Ann Machado - Re: 252-254 Commercial Street - Permit #2014-00545

I have just completed my initial zoning review for this permit. I need some more information before I can sign off for zoning and move the permit forward.

KEY PLAN &
EXTERIOR ELEVATION

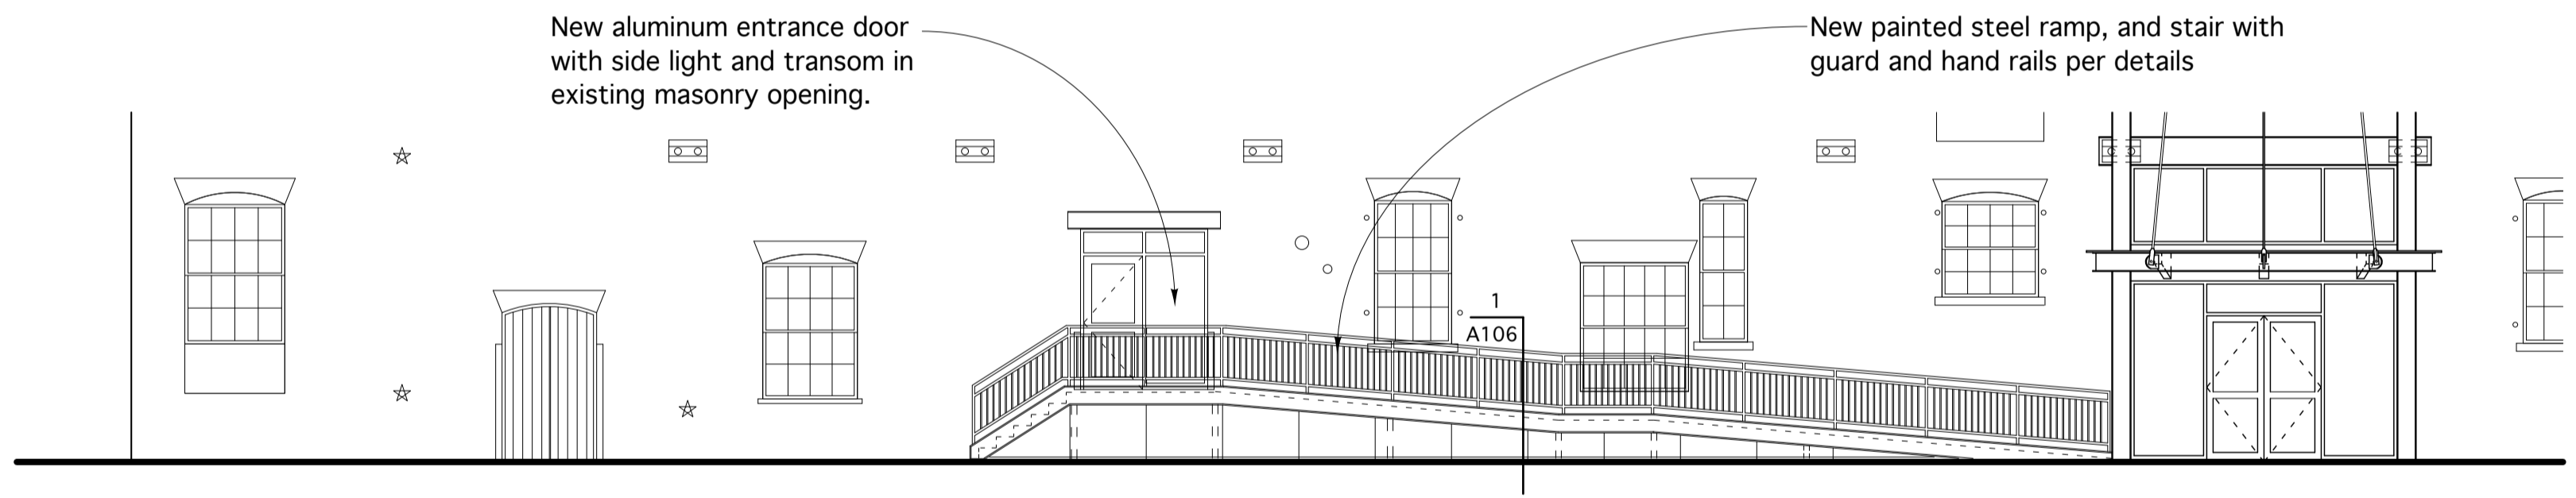
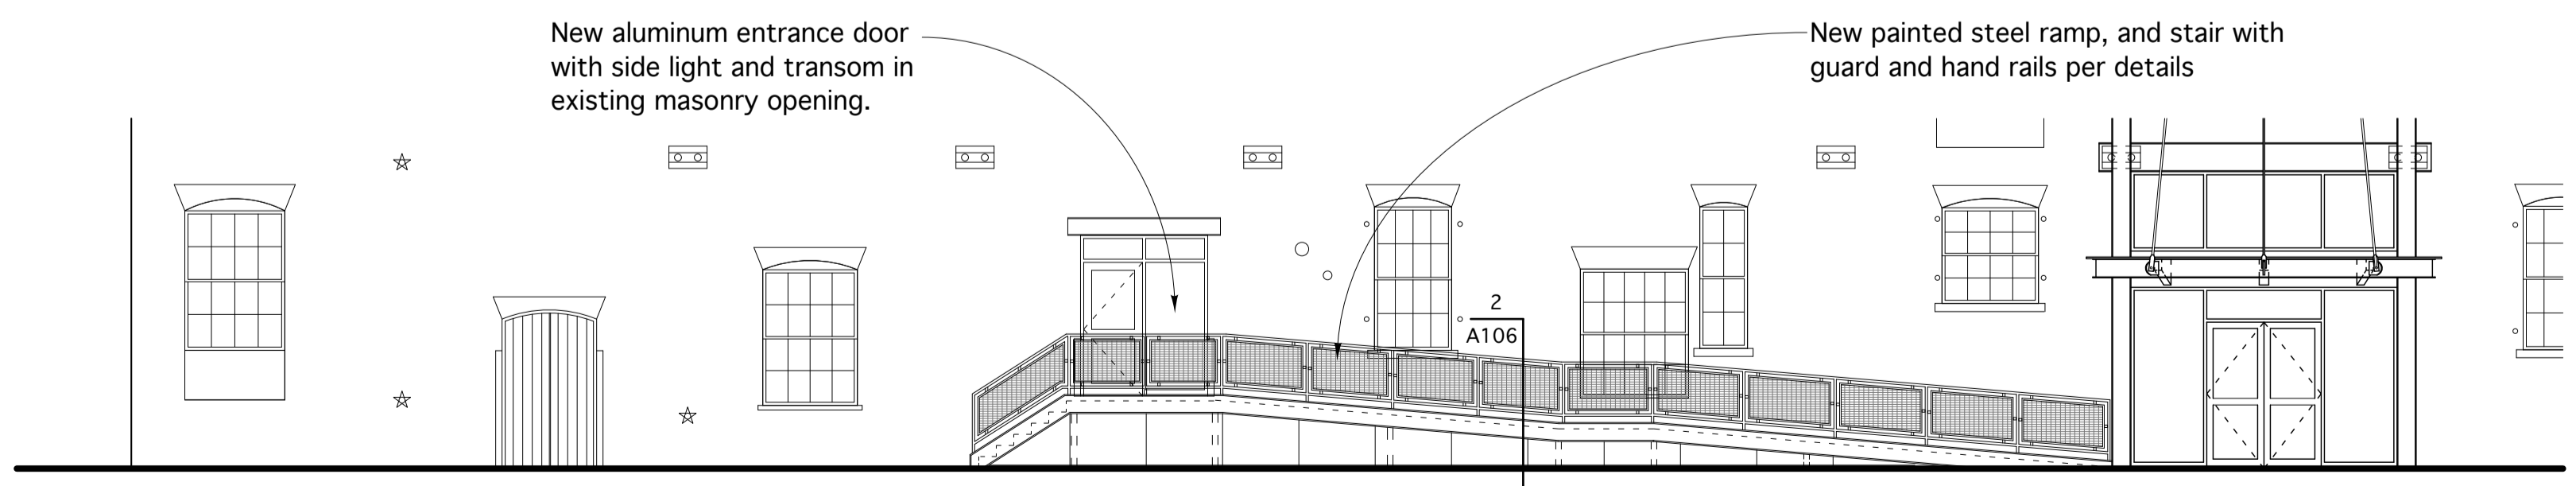
1. I understand that Unit A - Suite 119 is being split into two tenant suites that will both be marine uses. The plans name the tenants as Quest and Casey Prentice. You have included a determination letter from Marge (10/15/13) stating that Quest Navigation is considered a permitted use as Marine offices. The other determination letter (11/19/13) that you included was for CPB2 LLC. This business has already received a tenant fit up permit for Unit K -Suite 122. I need to know what Casey Prentice is to make sure it fits the permitted uses listed under marine uses. Also, which company is occupying which suite?

The answer to your first question is that CPB2, LLC and Casey Prentice are one and the same. You are correct that CPB2, LLC was already approved for a tenant fit up for unit K -suite 122. This was done because they needed to move out of their previous space sooner than we would be ready for them in the space thats now being permitted. So they are currently occupying unit K temporarily and will relocate to Suite 119A when the space is completed. Let me know if you think I should make some label changes /additions to the plans to clarify any of this.

MARINE USE ACCESS AND PARKING PLAN

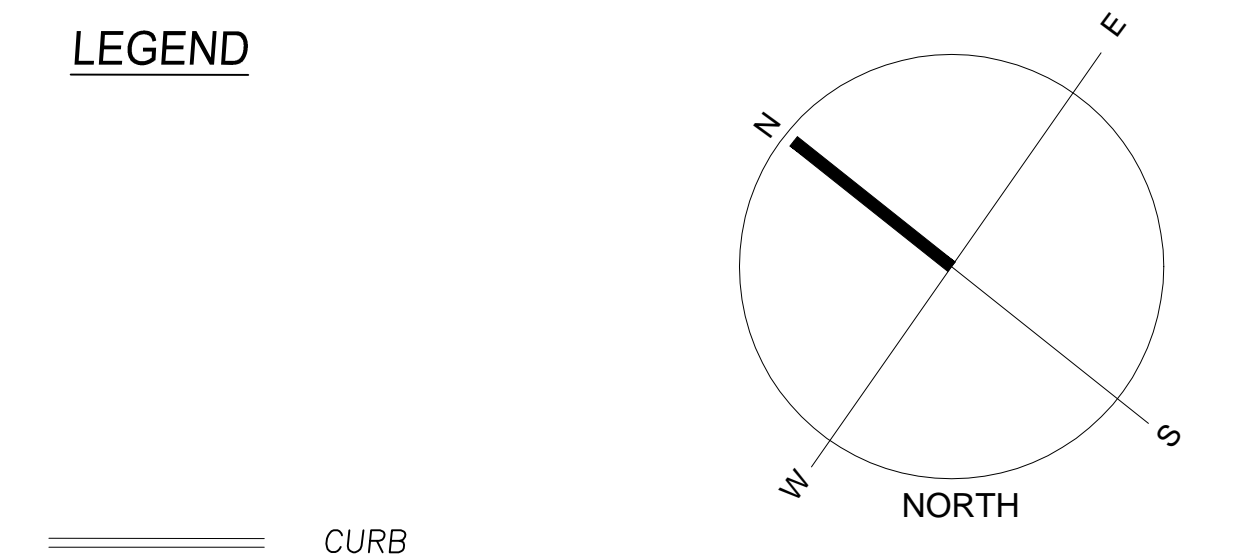
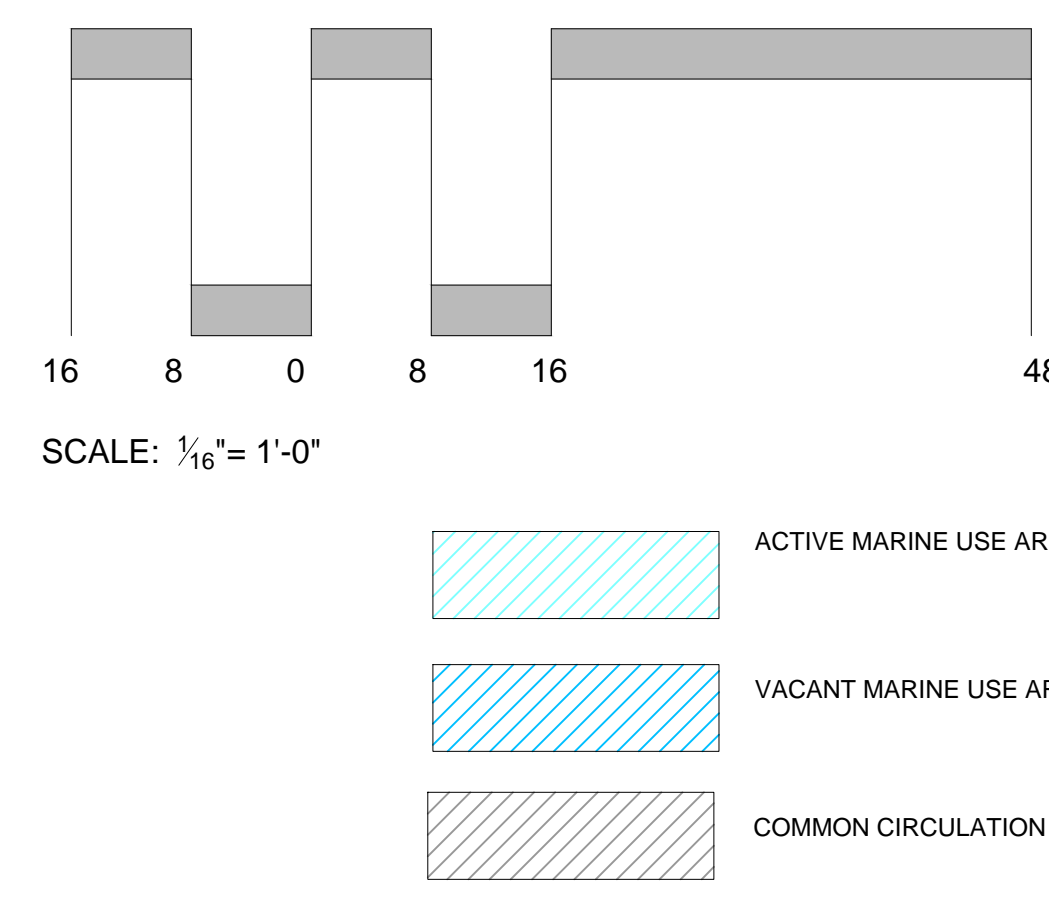
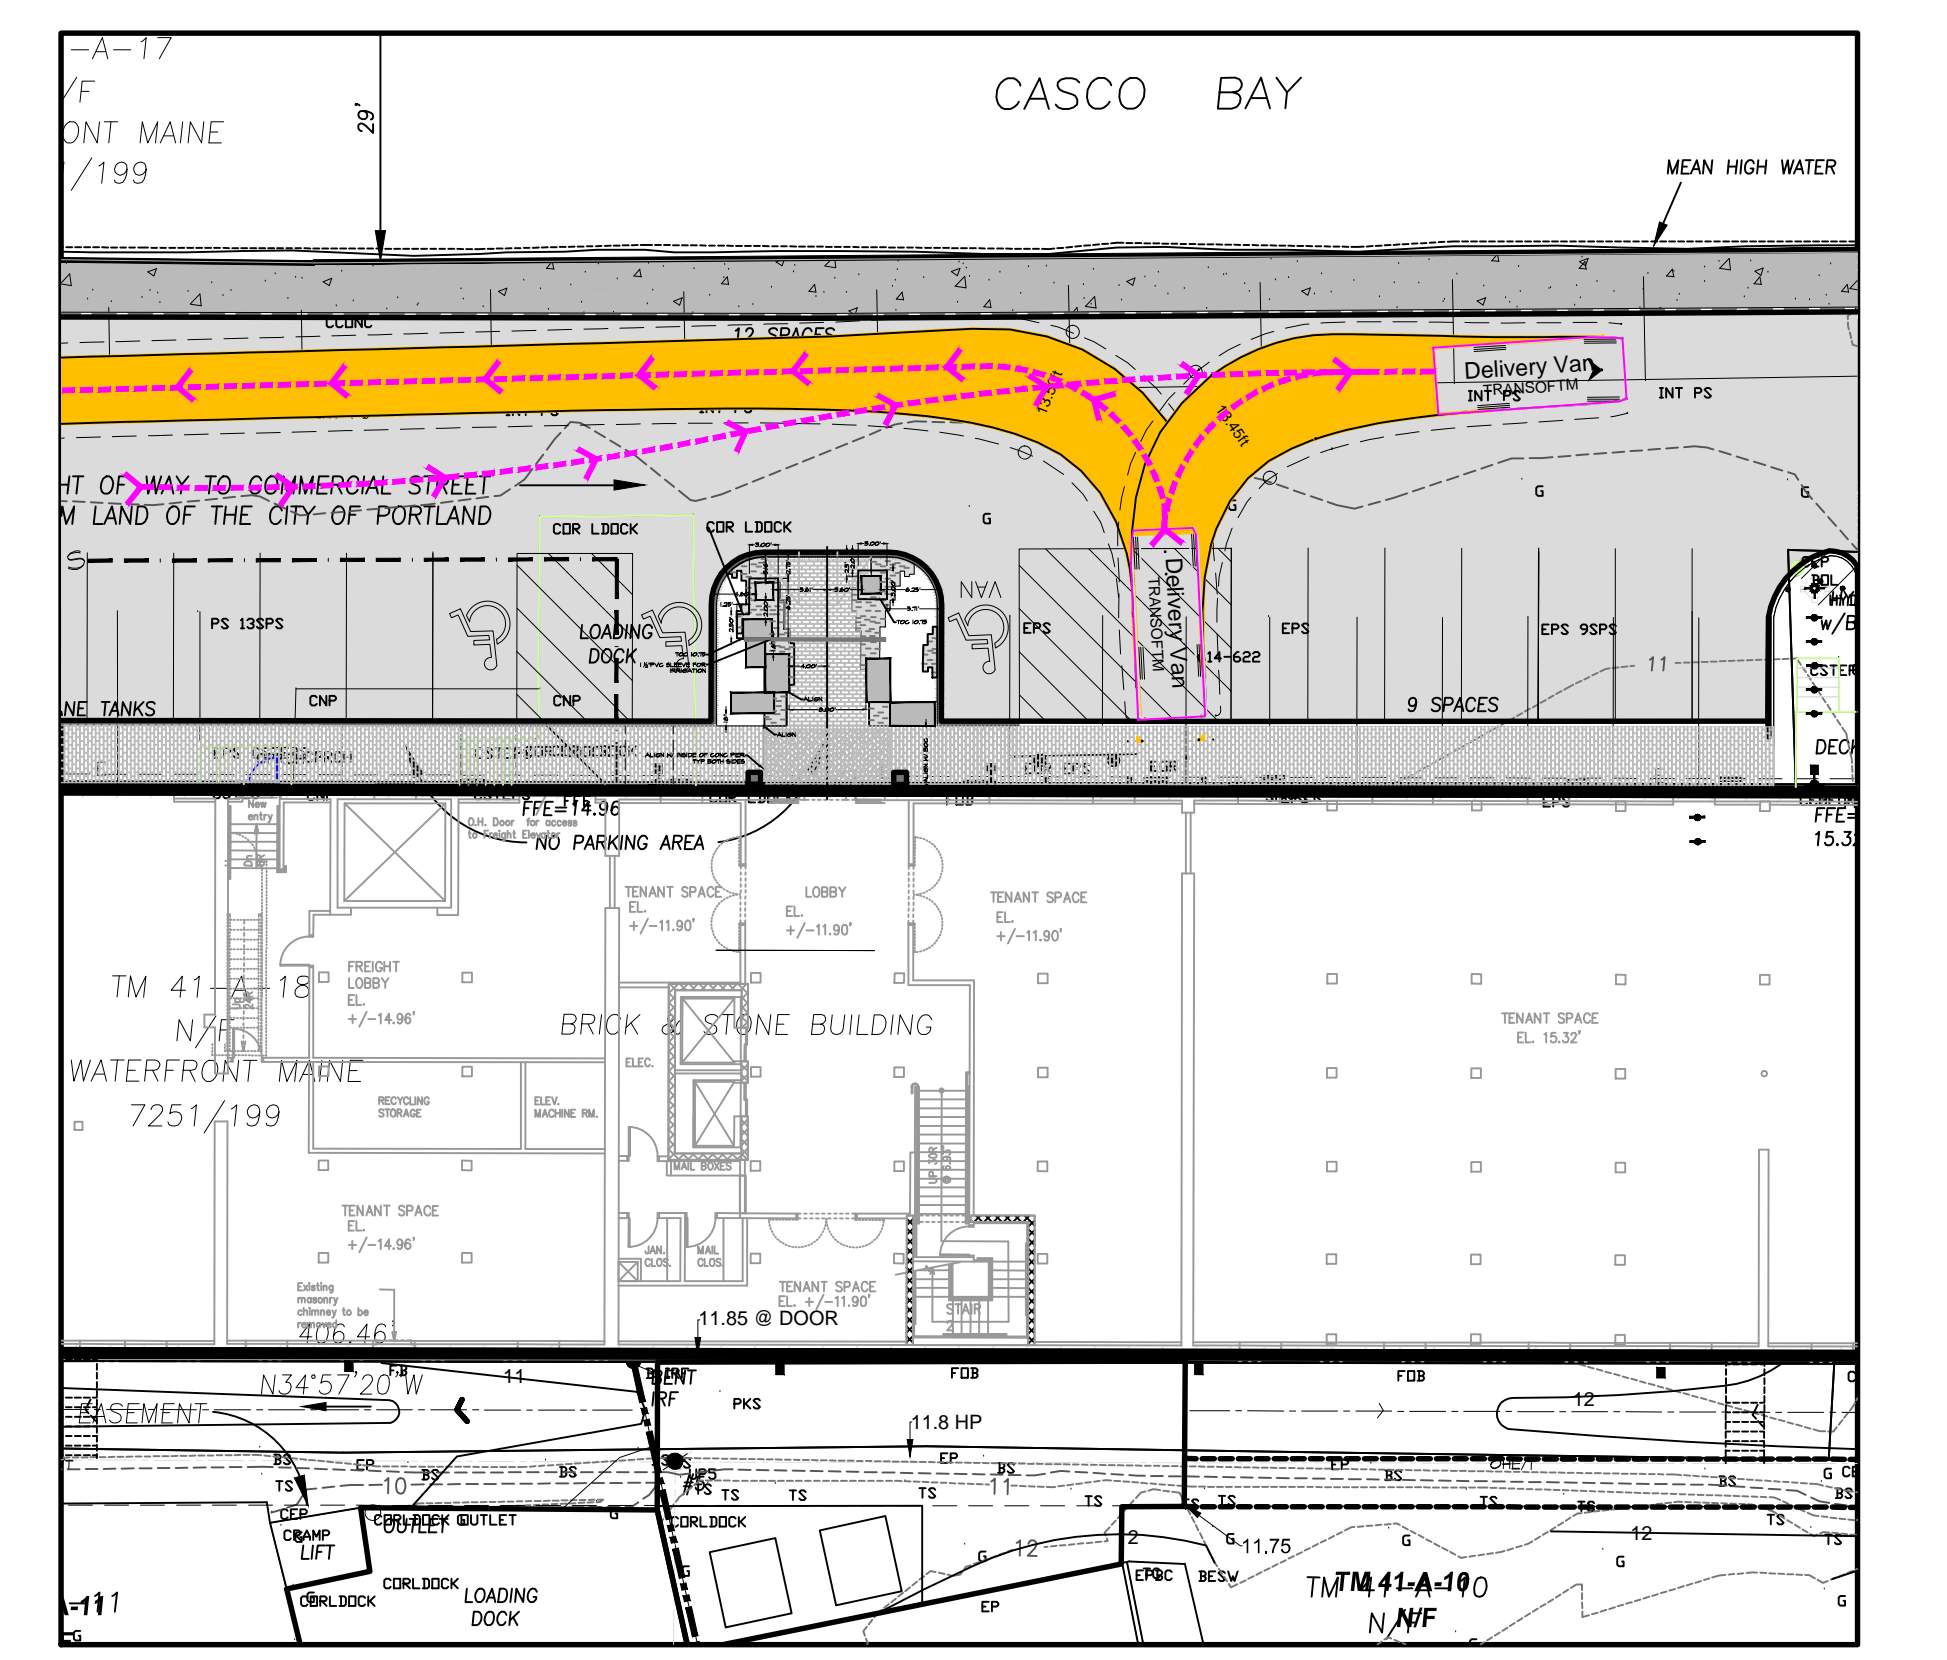
2. Part of this permit is to build the exterior ramp. You included a partial sire plan - S1.1 that shows the ramp location. WE need a full site plan of the whole property that shows the site plan.

I'm passing this on to Pat Carroll our Landscape Architect so he can get you the site plan.
